Application by Riveroak For An Order Granting Development Consent For An Airport At Manston Airfield

Application Ref: TR020002

Response to the Examining Authority's First Written Questions by the Historic Buildings and Monuments Commission for England (Historic England)

Dated: 15 February 2019

Figure 9.2a
Non-designated heritage assets (HER)
within study area

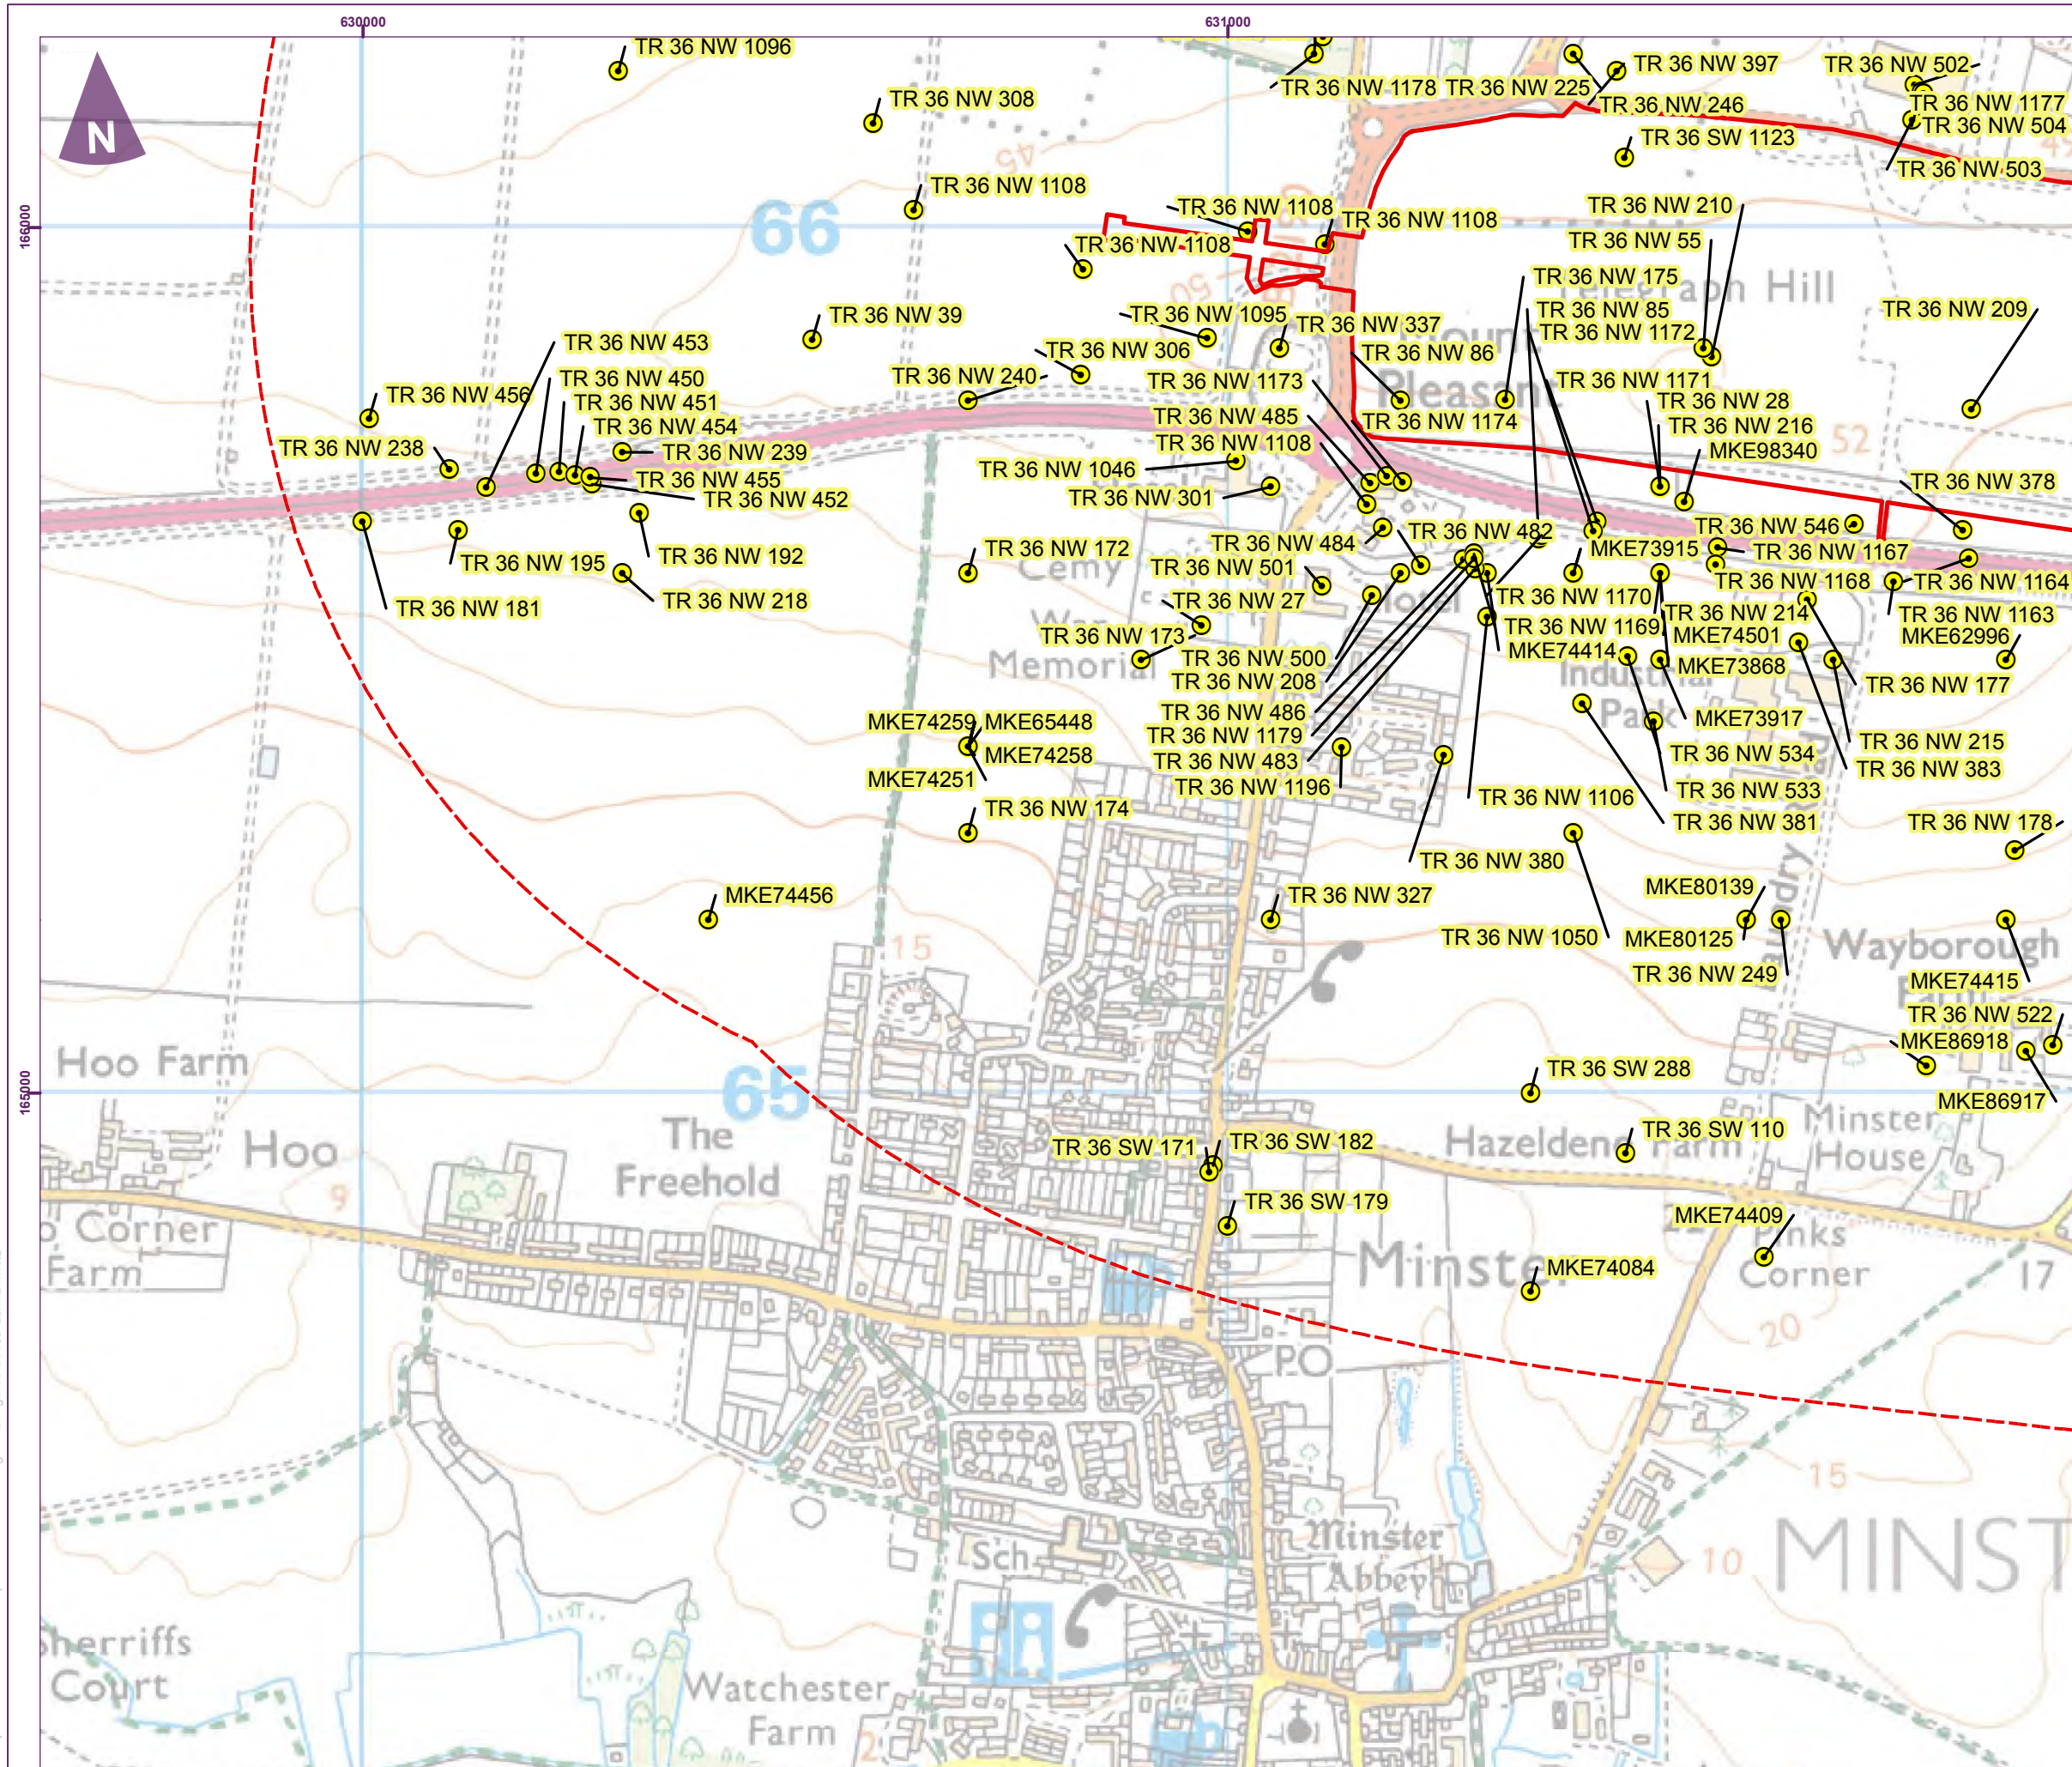
3.2. In the central and southern parts of the airport (south of Manston Road) archaeological survey and evaluation excavation has been undertaken and the results published, which we understand provides a useful indication of the likely heritage significance of buried archaeological remains there (although it did not cover all areas that would be impacted by the present DCO proposals).

3.3. Unfortunately, in the Northern Grass Area little archaeological survey and evaluation has been done, and that which has been done is apparently not available to us or the applicant. However, we believe that the airport lies within a very rich archaeological landscape in which numerous designated and non-designated archaeological sites of national importance have been identified and it is highly likely that archaeological remains of similar type and significance will also be found within the airport itself. Therefore, while there

is little clear evidence yet for archaeological remains that have significance that merits consideration in the decision we think that this is likely to change following further survey and assessment.

Figure 9.4
Built heritage assets within the site boundary

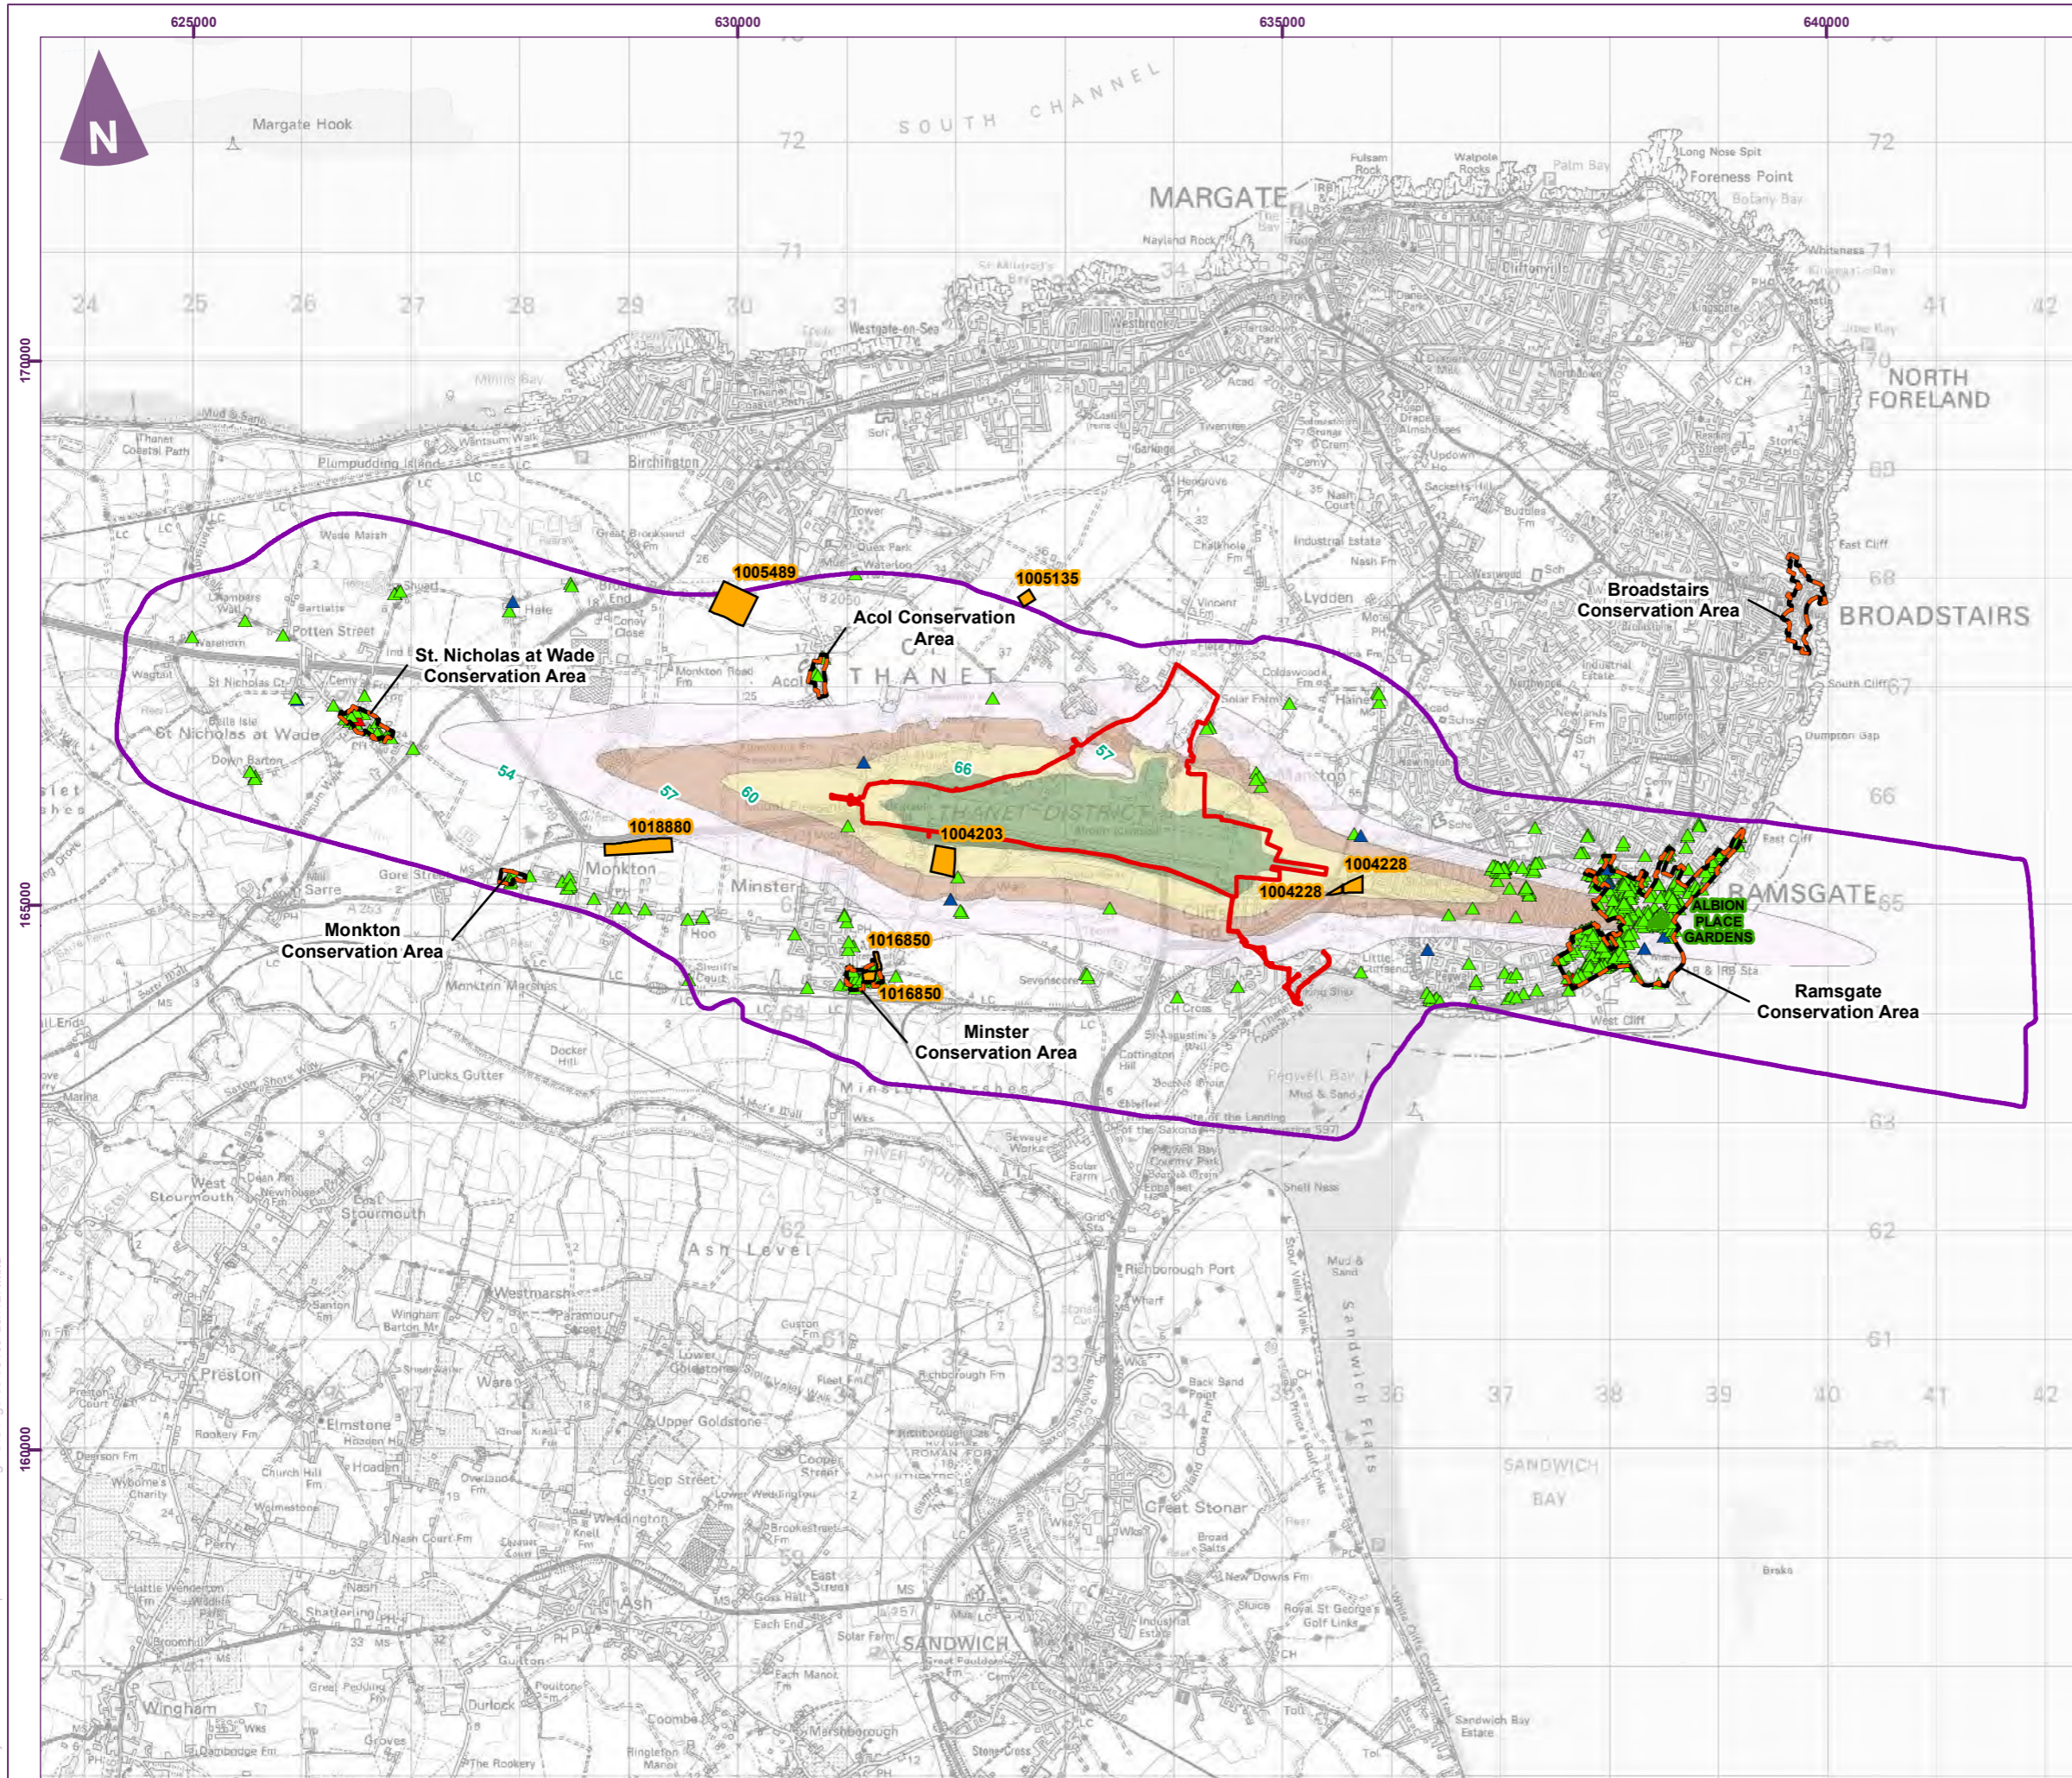
1.3.1. Enough information is available to indicate that there are certainly some important historic buildings on the airfield. It is Historic England’s view, on the basis of this information, that the T2 Hangar, WWII Dispersal Bay, RAF Manston Control Tower and the RAF Manston WWII Battle HQ are potentially nationally important and if so should be preserved. However, the relatively superficial survey on which the ES depends might prove to either underestimate or overestimate of the level of significance

for each building so decisions about which buildings should be preserved may not be well-founded with the result that unjustified harm might be caused or unjustified constraints on development might be imposed. Additionally, the ES is not clear about the applicant's proposals for which buildings would be demolished or retained, so consideration of the likely impact of the development is made doubly difficult.

3.4. The airfield is known to contain important historic buildings dating from its wartime use as an airfield but the actual level of significance of these buildings cannot properly be confirmed without historic recording and analysis. Therefore, there is some clear evidence that historic buildings have significance that merits consideration in the decision and further survey might produce more.
